Application for a non-material amendment following a grant of planning permission.

Proposed two-storey side extension to dwelling including associated works	
Reference number:	H17-0367-18
Date of decision	18/06/2018

1st floor master bedroom to be made wider

0316(20)003

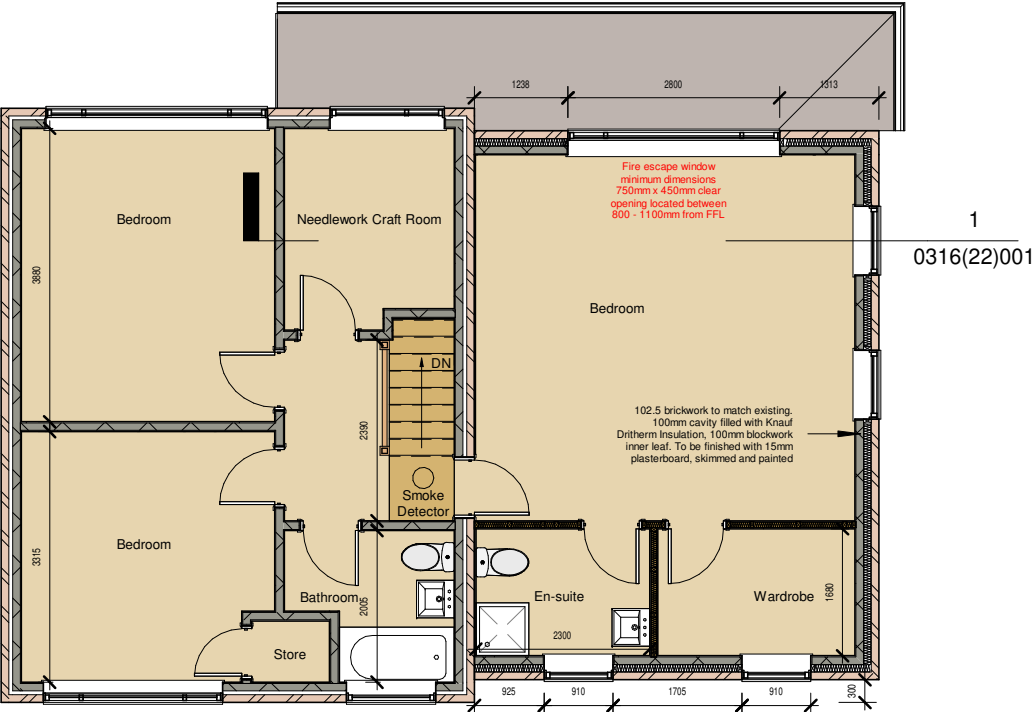
Larger bedroom / en-suite / dressing room required by applicant.
